KITTITAS COUNTY

MEMORANDUM

TO: All Staff
FROM: Justin Turnbull, County Surveyor 
DATE: April 3, 2019
SUBJECT: County Survey Review of Final Plat LPF-19-0002 (Ranch Rd Final Cluster Plat)

RANCH ROAD PERFORMANCE BASED CLUSTER PLAT

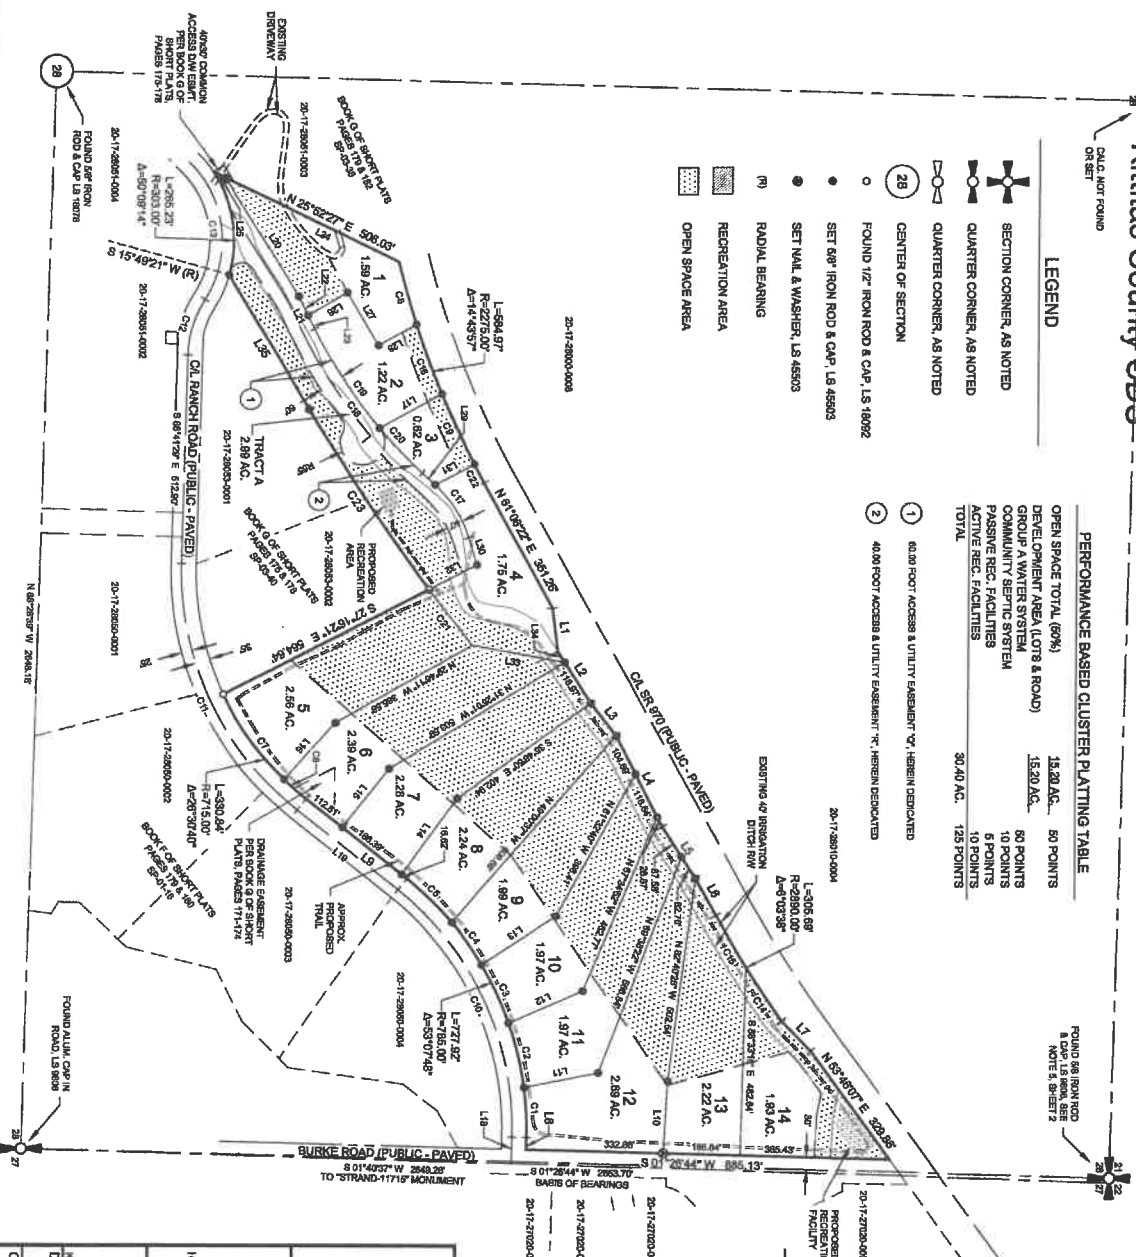
- 3. The ownership of public right of way should be clarified as being county or state.*
EX: "Burke Rd – County R/W – Paved"

This should be shown for all roadways including state and county owned right of way.

The portion of the Old Sunset Highway North of the bend of Burke road may be labeled just as county right of way, as there is no official road designation for this portion.
